Please ask for: Mrs D Johnson
Email: daun.johnson@arun.gov.uk
Telephone: 01903 737762
Our Ref: BR/63/22/PL
Your Ref:
Date: 28th March 2022

Application for Planning Permission

Development: Change of use of 5 No self-contained flats for adults with learning difficulties to 5 No self-contained flats and formation of 5 No further flats from HMO rooms, garage and office, repairs and decoration of external surfaces, minor alterations to elevation facing Sadler Street, change one window facing rear courtyard to French doors & apply obscure film to 2 windows in courtyard area. This application affects the setting of listed buildings, affects the character & appearance of The Steyne Conservation Area and is in CIL Zone 4 (Zero Rated) as flats.

Location: Salisbury House The Steyne Bognor Regis PO21 1TX

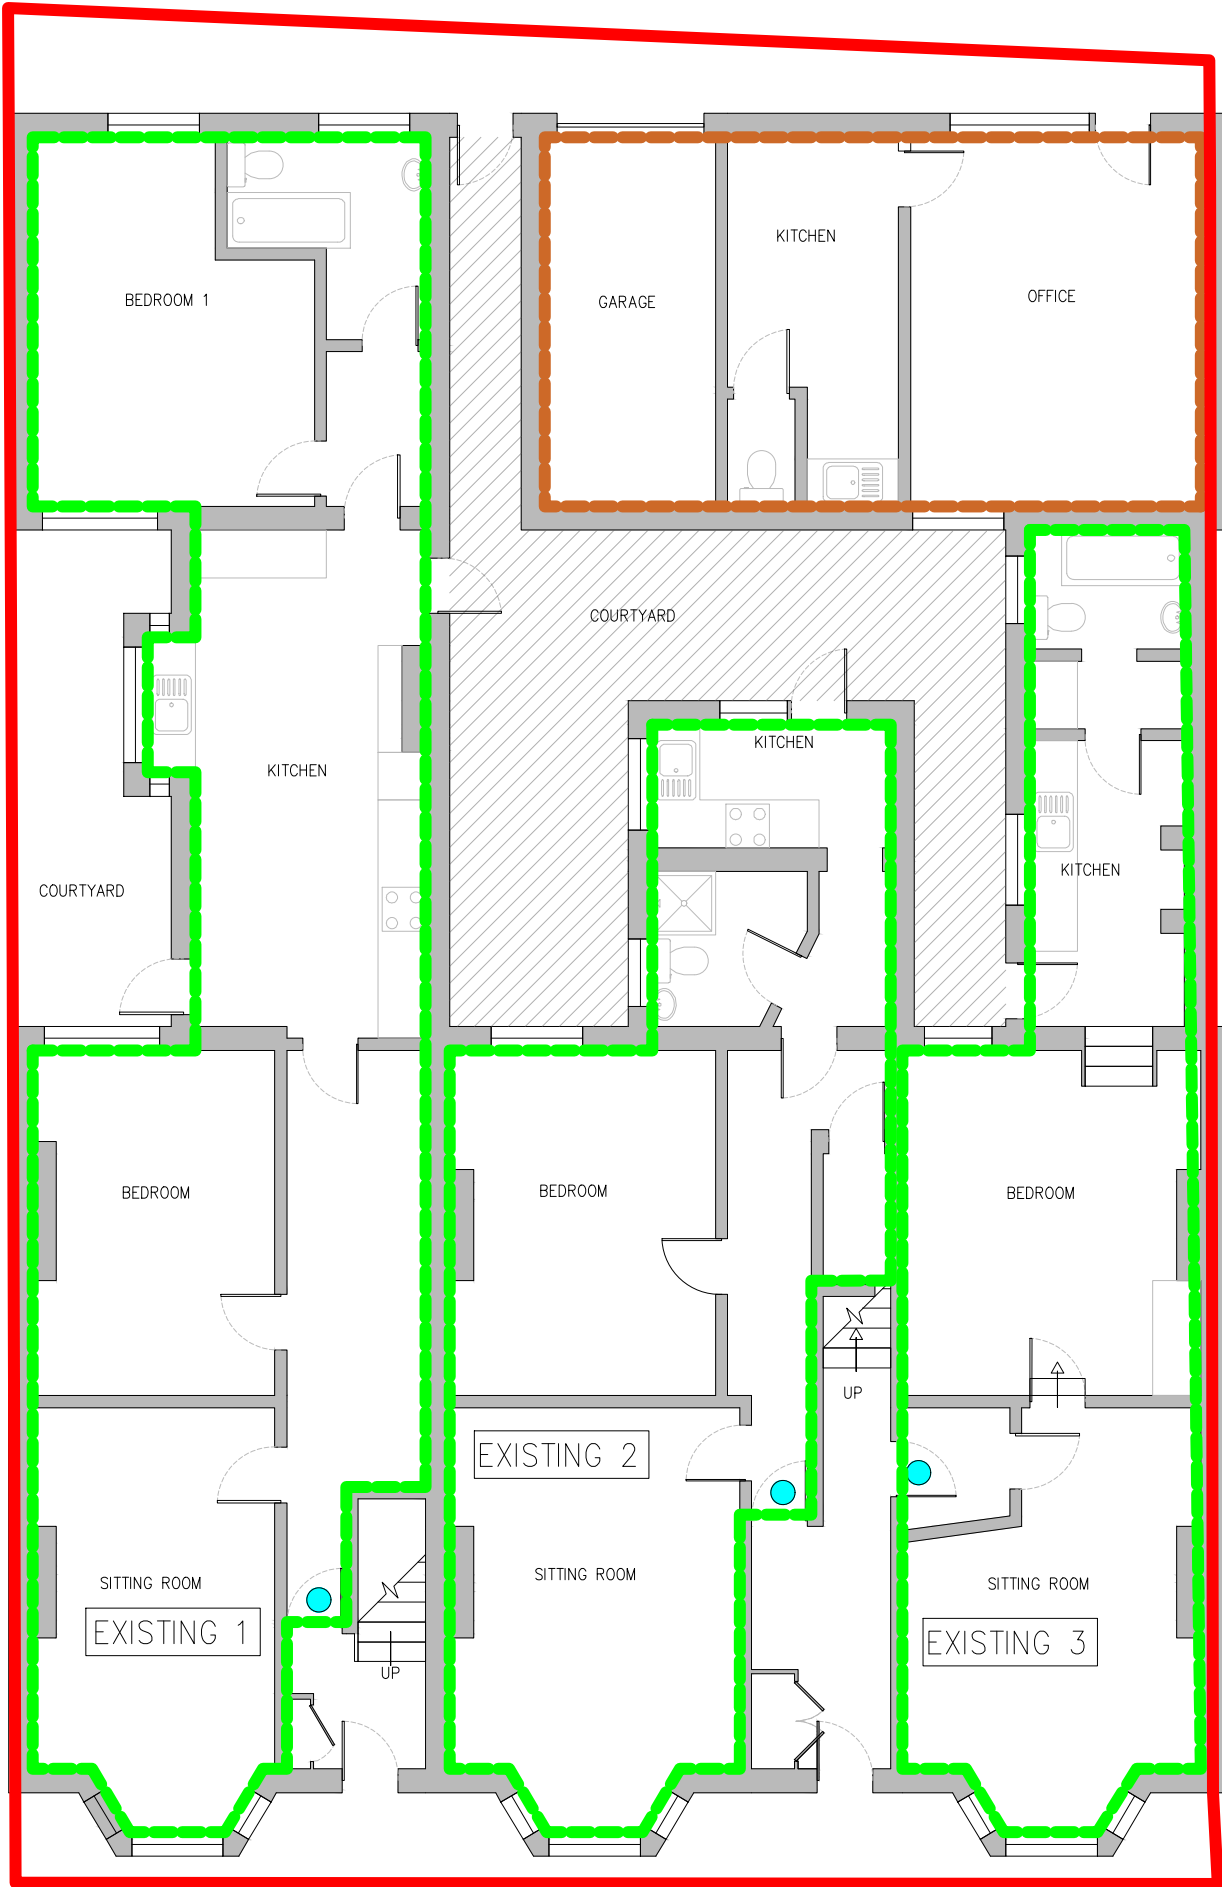
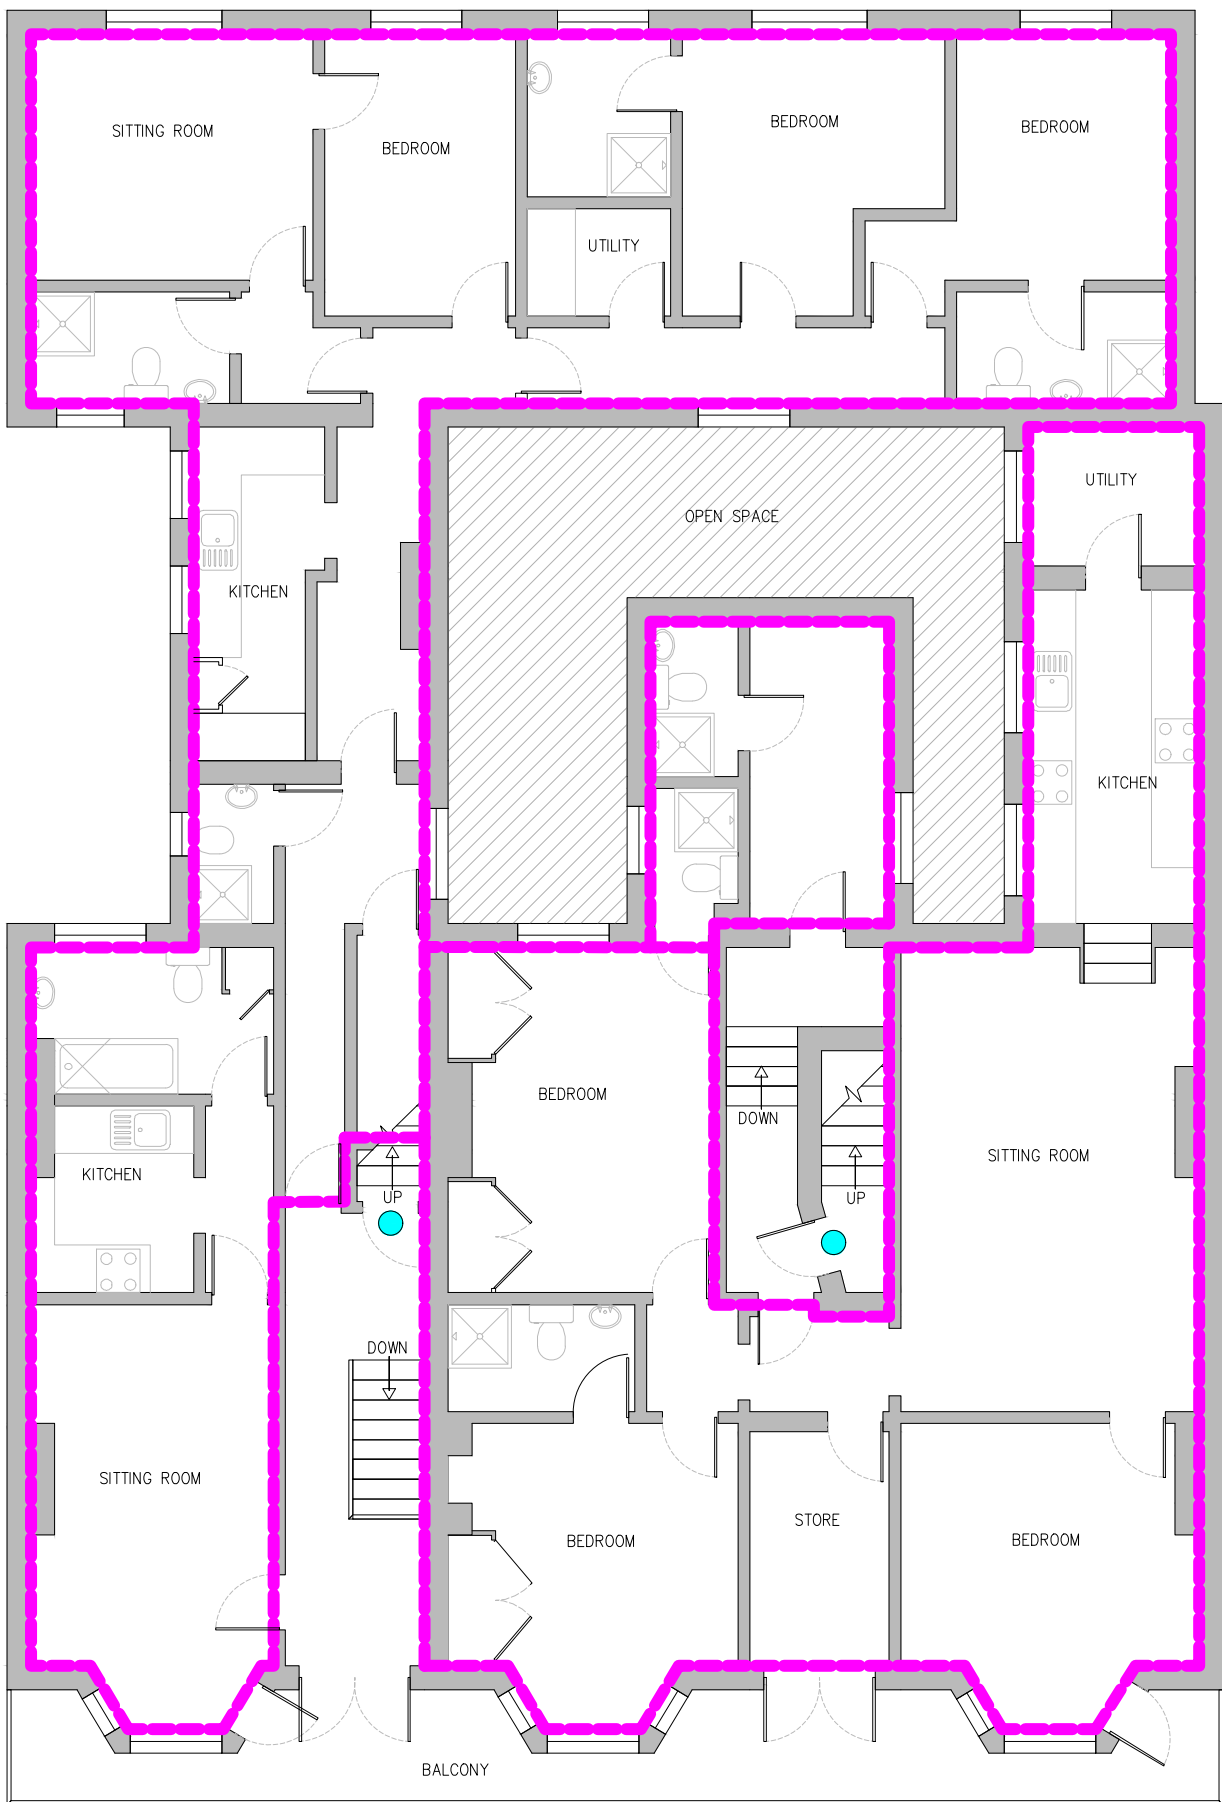
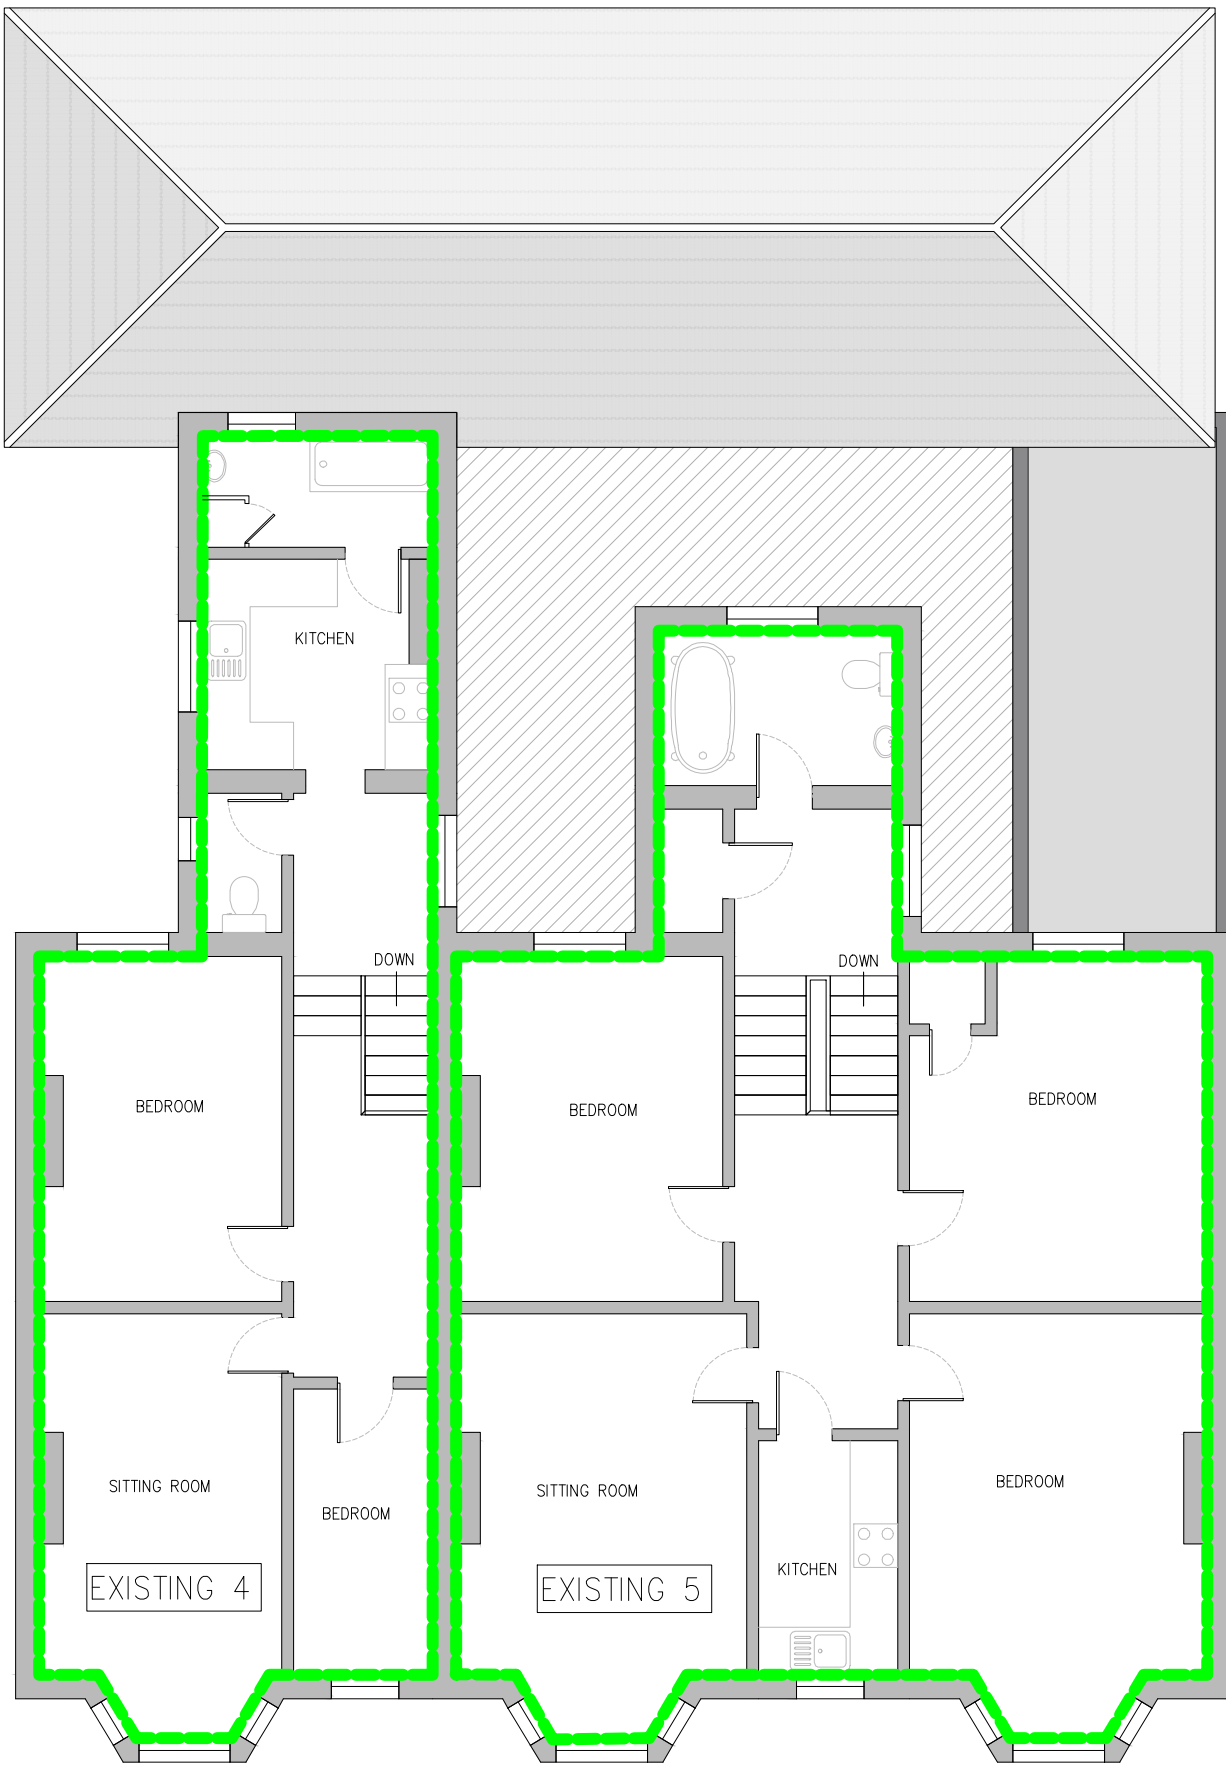
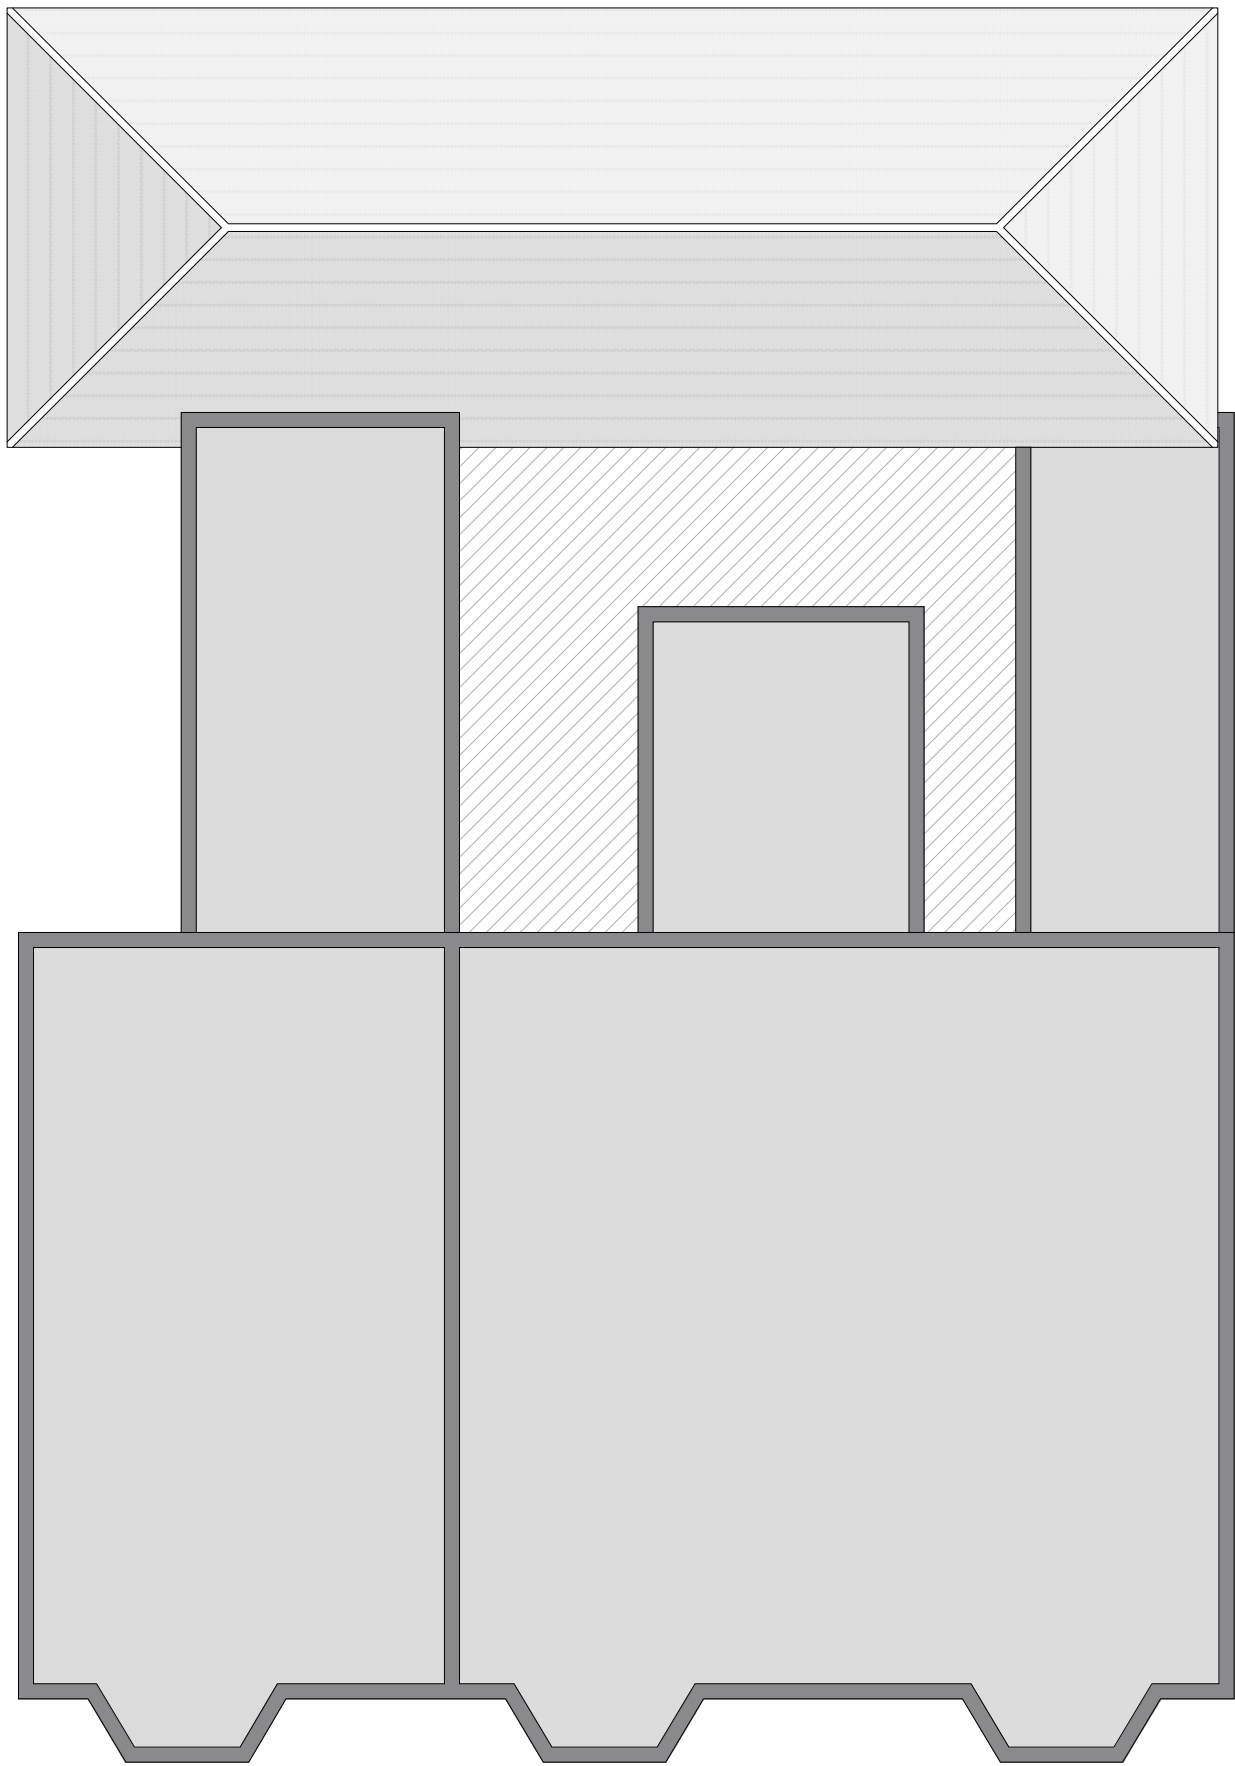
In the description of the proposed works 'change of use of 5 self contained flats with learning difficulties to 5 self contained flats', however, the existing floor plan shows no self contained flats. Please clarify.
